Essex Local Access Forum (ELAF) deadline 3 submission (9 March 2023)

Interested Party ref 2033138

Drawing title: **STREETS, RIGHTS OF WAY AND ACCESS PLANS SHEET 14 OF 21**

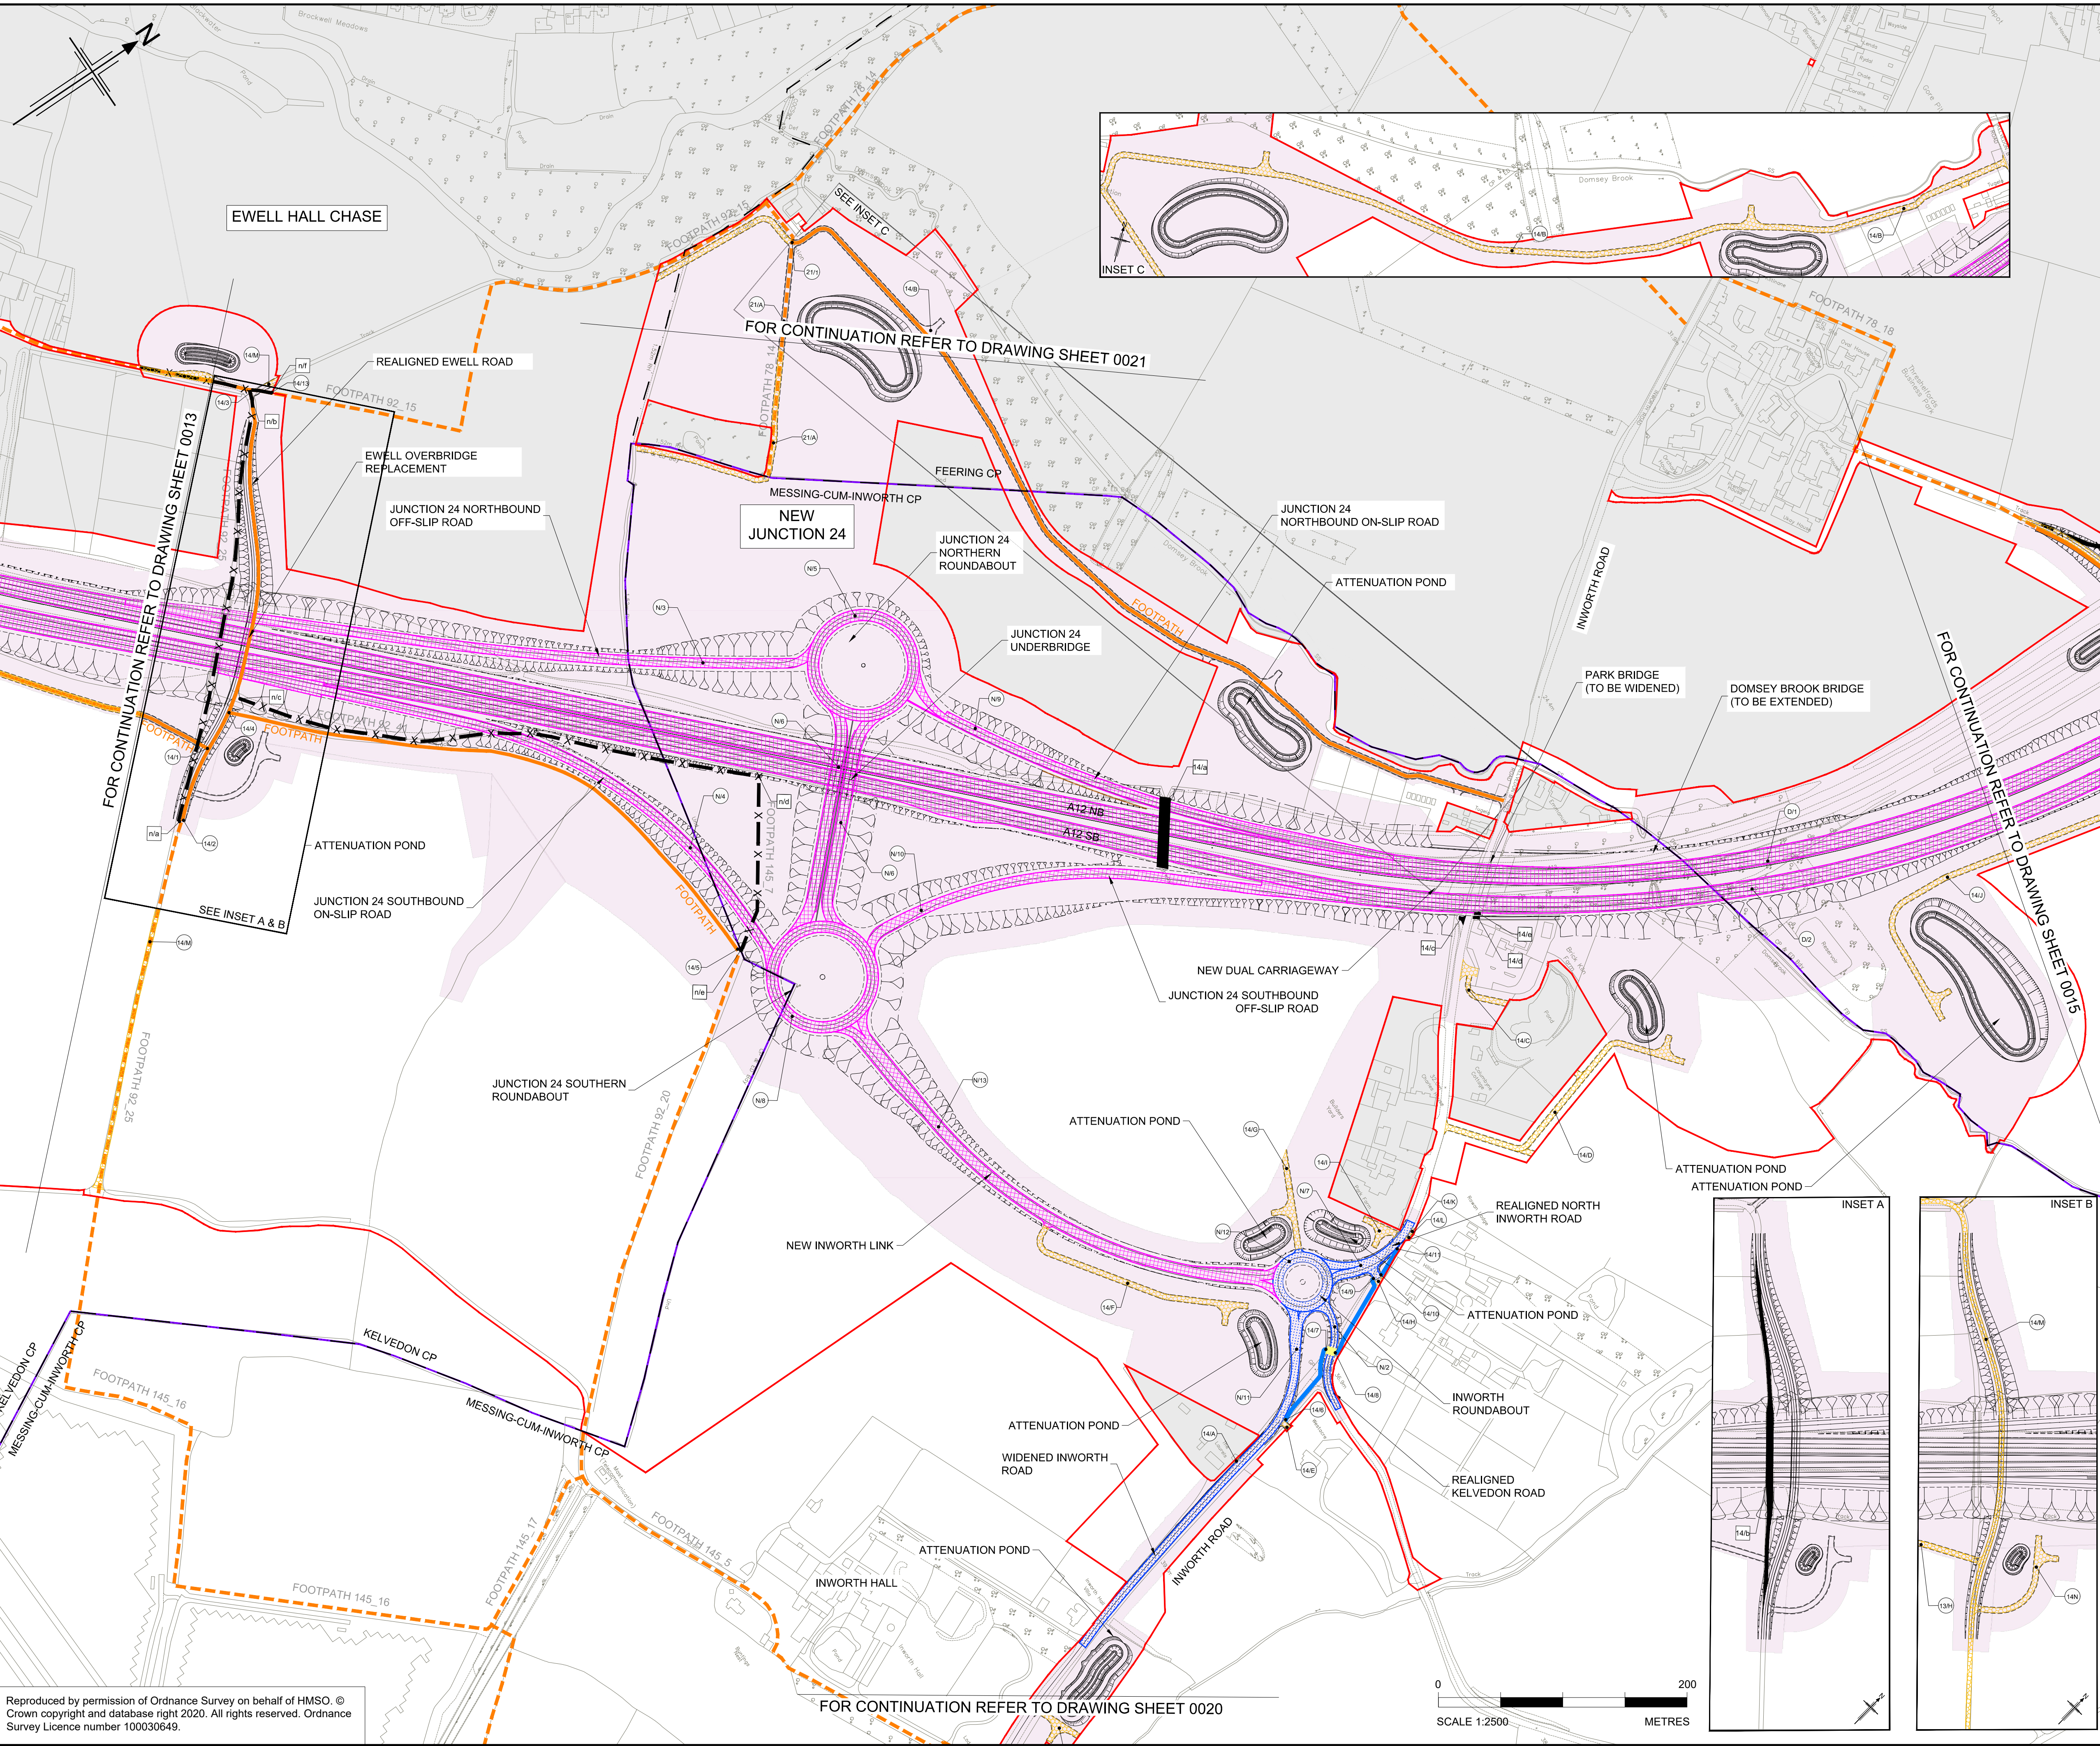
The request by Shirley Anglin at the Land Use ISH1 that Ashman's bridge and the connecting PROWs should be an inclusive WCH route is welcomed. The existing footbridge over the river Blackwater is due to be rebuilt and the line of most of the PROW is having to be moved, inside the red line Order Limits, to accommodate the changes in the A12 at the west end of Kelvedon [AS-008 2.7 Streets, Rights of Way & Access Plans revP02 sheets 12 &13].

In ELAF's deadline 2 submission an extension east/ north-east was requested as a WCH route, on National Highways land, preferably not immediately adjacent to the A12, to Inworth Road. [AS-008 2.7 Streets, Rights of Way & Access Plans revP02 sheets 13 & 14]. This would provide a circular accessible route for the expanding population of Kelvedon and Feering.
